**Planning Application Reference No.:** 3/2023/0540

**Address of Development:** Land off chaple hill hall barn drive longridge pr32yd

Planning Application No. 3/2023/0540 Chapel Hill Longridge

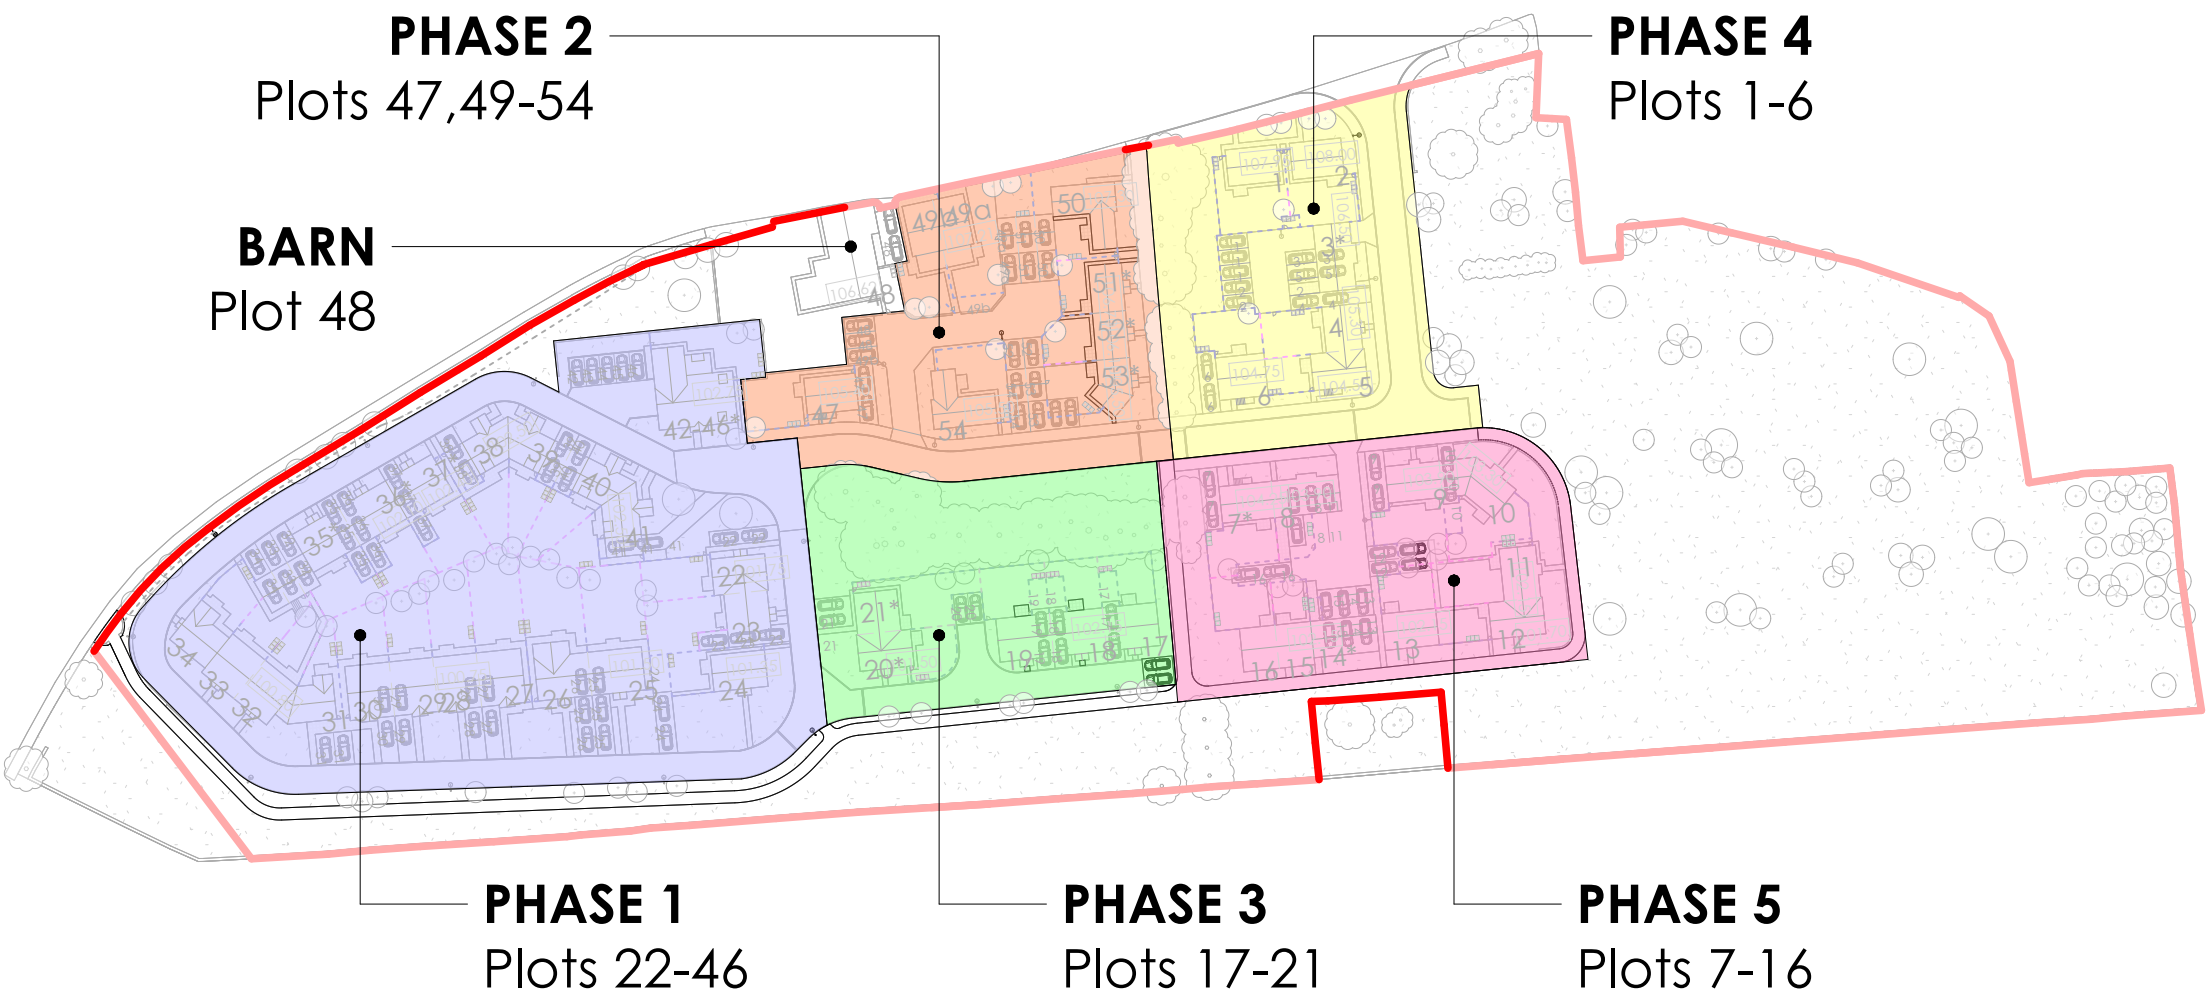
2. The rather spurious statement in the application letter which claims that the pond was an unimportant side issue which is no longer required seems to hide the unspoken bits that show their intention to remove the footpath from the Eastern part of the site as well as access by the planned installation of a new fence which will effectively prevent access into the Public Open Space. In their letter they merely say, 'The main purpose is to remove the pond.' However on Drawing Rev J it speaks of :

- I. Pathway removed;
  - H. Pathway updated .
  - G. Pond removed
  - F. Design updated
3. There is a matter of the unlawful dumping of building spoil. This has raised the land surface and removed the gentle slope that features in The Conservation Statement. Approx. 2 M difference is easily observed which does not seem to be accounted for in their application even though they point to one specific place with an arrow and write words that imply ? WHAT? To the naïve amongst us it can be interpreted as they intend to restore the buried levels. Perhaps their interpretation is different. Perhaps the applicant will claim, after planning approval is granted to legitimise the situation, that the level indicated is existing and

Upon closer examination of drawing CN-00-001 Rev J shows the removal of footpaths and access routes to, and through, the area and furthermore they intend to install a new fence, without breaks, which will effectively render the area closed-off from public access. The original scheme shows an access/egress pathway connecting to the bridle path adjacent the houses lower down Chapel Brow.

The fence line is clearly shown on the drawing extending from the new wall, yet to be built, adjacent the road at Chapel Hill down almost to the southern boundary adjacent the reservoir wall. This is already marked as a 'swale' on the approved landscape plan and is not now, and won't be on completion, an easy access route for foot traffic and mums pushing prams. Afterwards, it is also very easy and quick to install a further obstacle to ensure access is impossible. Why then is the pond an issue?

Reference to Drawing No.CN-00-001 Rev G shows the earlier incarnation of the drawing with paths and access as defined in early planning approvals although the pond is omitted. Both drawings are in the same application package and it is very easy to miss the significance of the differences. It is puzzling that the marketing effort by Agents acting for the owner have emphasised the pond and the adjacent reservoir as an important feature to be valued by the new residents and the wider community. How odd for such a reversal of attitude. This totally contradictory affair causes me to wonder what may be behind this planning application to seek RVBC approval for these changes.

Inspection of the new drawing Rev. J named above says:- '*Green space to be returned to existing site levels as indicated.*' There is an arrow pointing to a named level that happens to be at the original level provided by Survey Operations to United Utilities. The other levels on this drawing version J, shows figures which I take to be extracted from that original survey. At the lower levels near the south boundary wall at the reservoir it shows levels of 100 plus/minus decimal points. This indicates a gradual slope from top to bottom of about 3M.
